**RE: State Significant Development – Kings Park Material Recycling Facility (SSD-10396) at
23-45 Tattersall Road, Kings Park**

Thank you for notifying Sydney Water of SSD-10396 which proposes to increase the capacity of the Kings Park Metal Recovery to receive and process up to 600,000 tonnes per annum from 350,000 tonnes per annum. In light of new information received from the RtS phase, Sydney Water has reviewed the application based on new information supplied and provides the following amended comments to assist in planning the servicing needs of the proposed development.

Critical Assets:

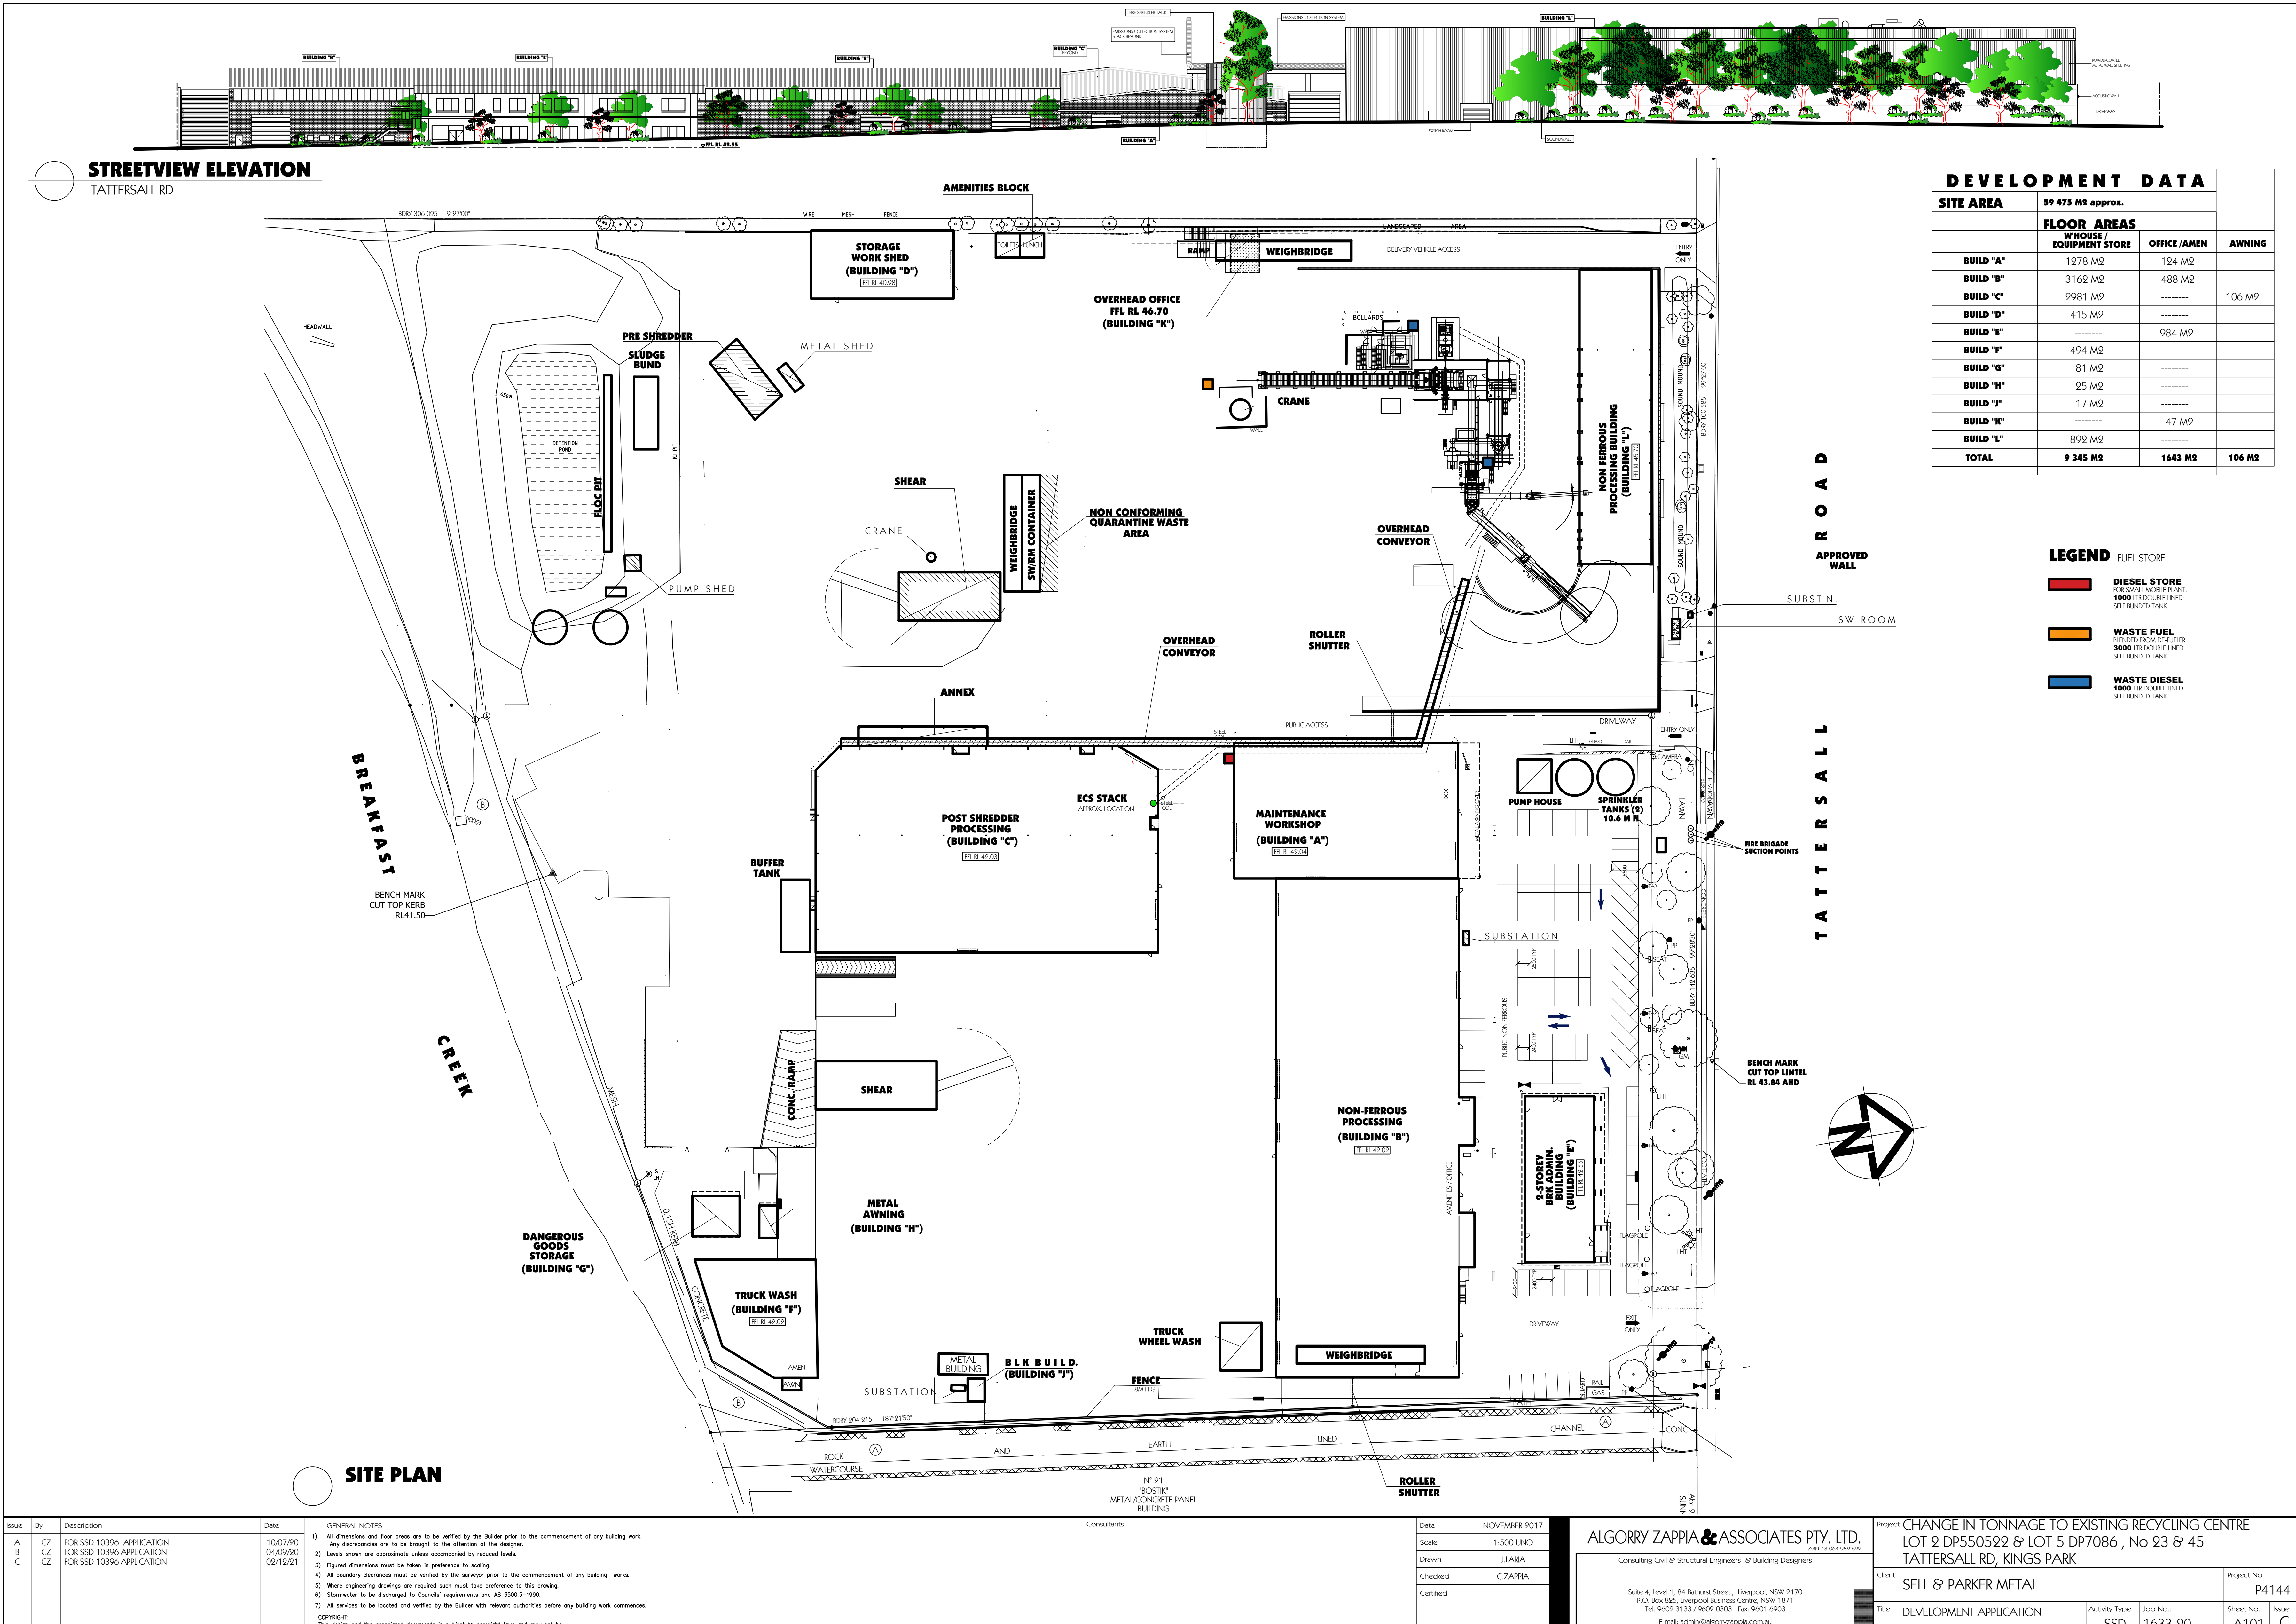
- **Sydney Water has no objection to the proposal in principle.**
- However, we note there are multiple 525mm branch wastewater mains traversing the site.

- Although the proposed development involves no demolition or construction works, **Sydney Water understands the proposed position of heavy machinery stacking and a shipping container wall over and adjacent to the branch main running parallel with the centre north-south property boundary within the site poses serious potential risks to our assets.**

- Specifically, Sydney Water needs to understand whether the shipping container wall is a temporary or permanent instalment. Concrete encasement may be required for sections permanently affected by the works. Long/extensive sections of concrete encased pipes are generally not preferred. Otherwise temporary protection measures may be required.

- Any temporary loading situations also need to be assessed as part of the SEA to demonstrate negligible/acceptable impacts on our assets.
- Considering the size and importance of these branch mains, such loading may not be permissible, and the proponent may need to create exclusion zones for these critical assets to avoid any heavy machinery movements and shipping container loading occurring over them.
